STERLING RECYCLING
FACILITY
TYPICAL SECTION

STERLING RECYCLING FACILITY
 EROSION CONTROL PLAN

STERLING RECYCLING FACILITY
 POND PLANS

CURVE	DELTA	RADIUS	LENGTH
C1	90°00'00"	15.00'	23.56'
C2	90°00'00"	15.00'	23.56'
C3	7°12'13"	50.00'	6.29'
C4	18°42'57"	50.00'	16.33'
C5	11°30'44"	50.00'	10.05'
C6	18°36'58"	50.00'	16.25'
C7	31°25'53"	50.00'	27.43'
C8	12°48'56"	50.00'	11.18'
C9	18°55'12"	50.00'	16.51'
C10	130°44'42"	50.00'	114.10'

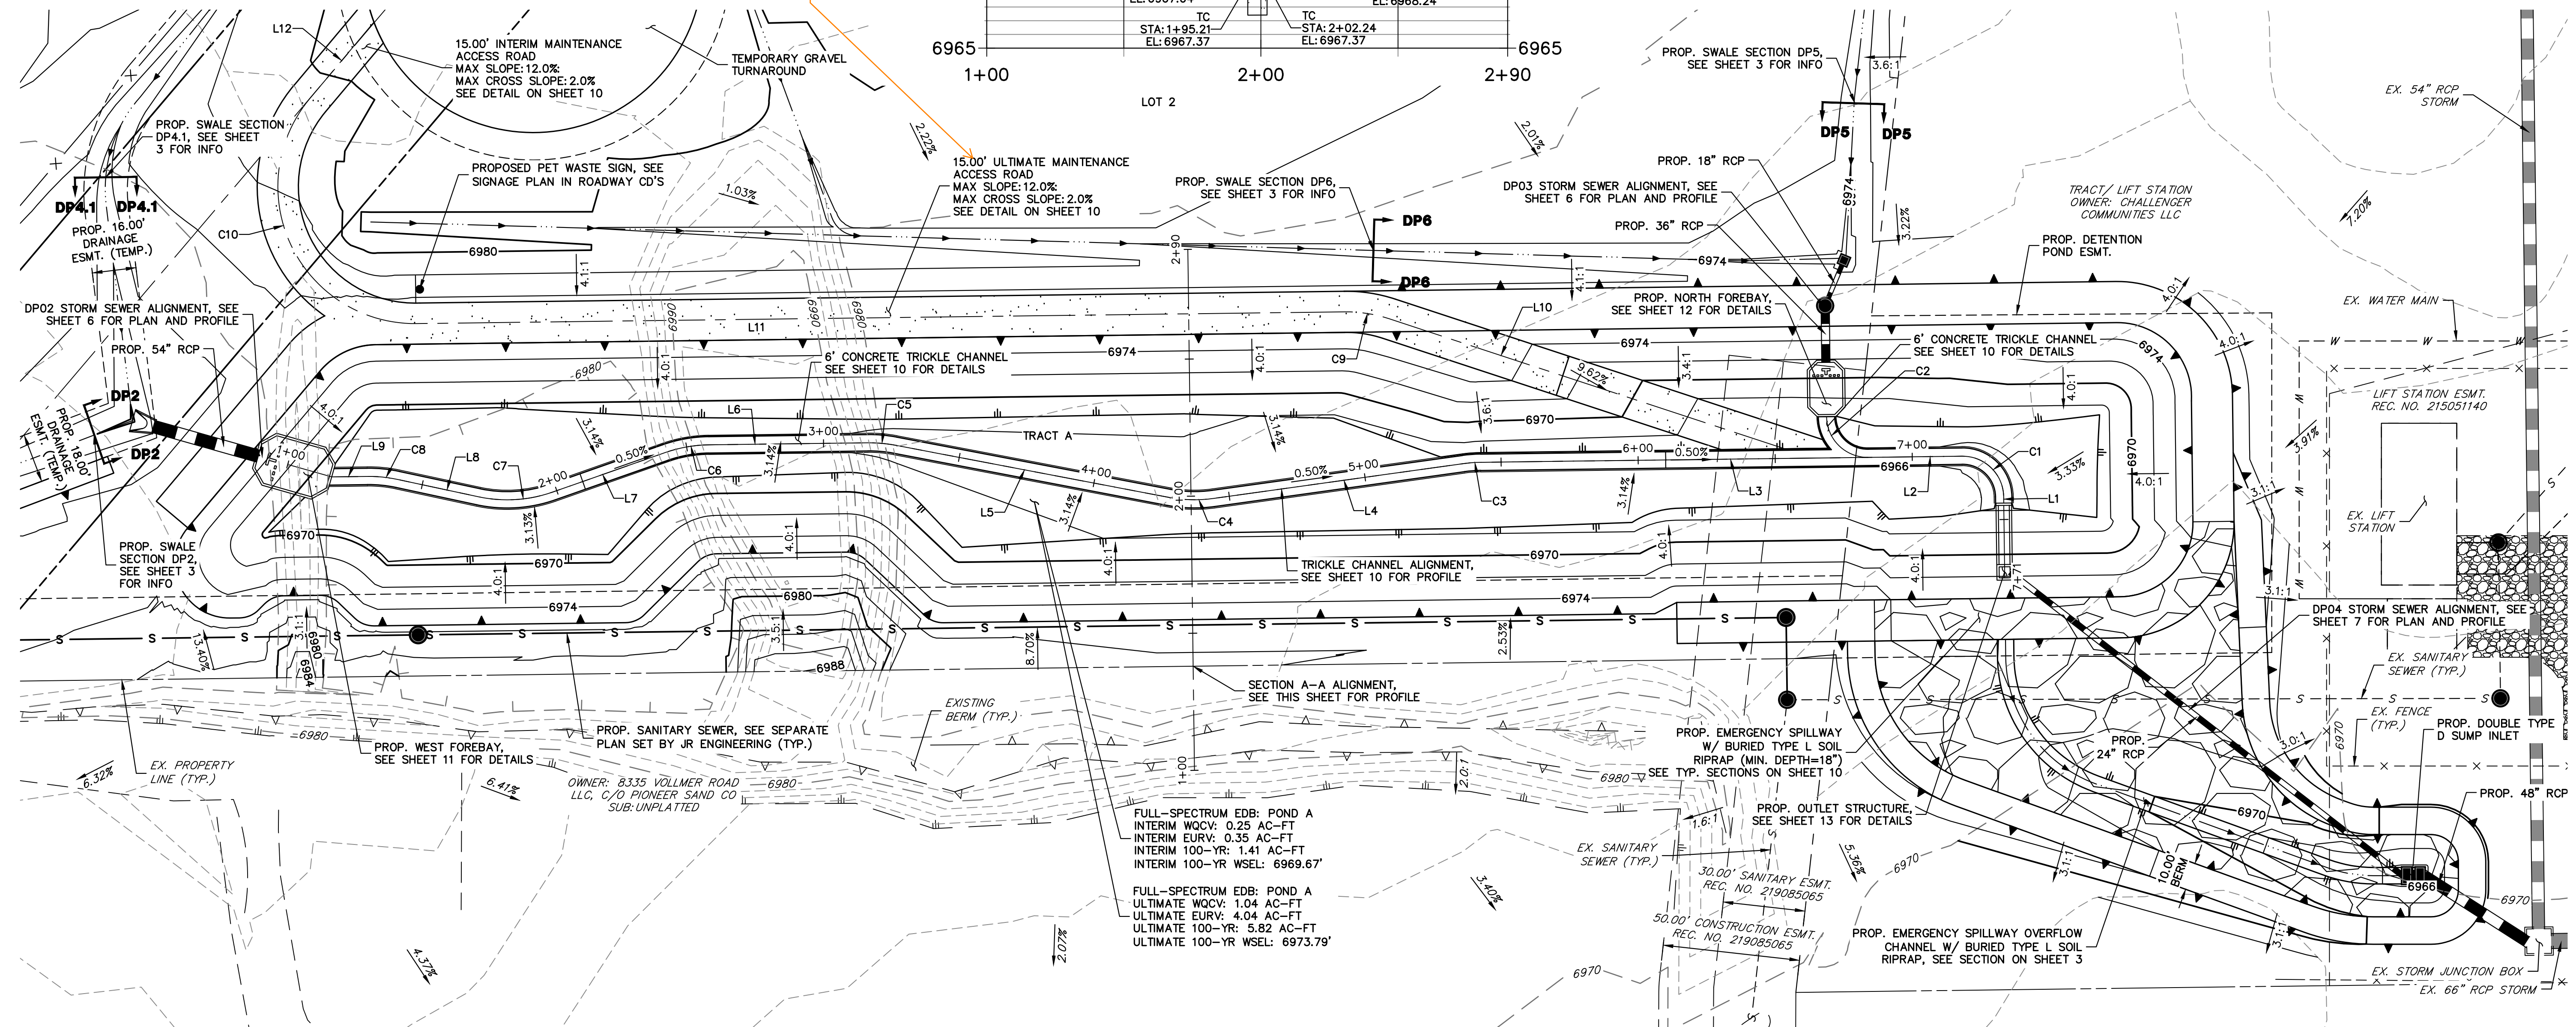
Unresolved comment from Review 1:

For larger ponds, stabilized access shall extend to forebay(s) and outlet structure per MHFD Detail T-5 and DCMv2 - Chap 4.2.

Also, consider rolled curbs where the access road is to cross trickle channel.

JR Response: Added statement to the Pond O&M manual about the access to the forebay(s) and the outlet structure using the tickle channel. It is wide enough for the anticipated vehicles and equipment for future maintenance. Added note on this sheet.
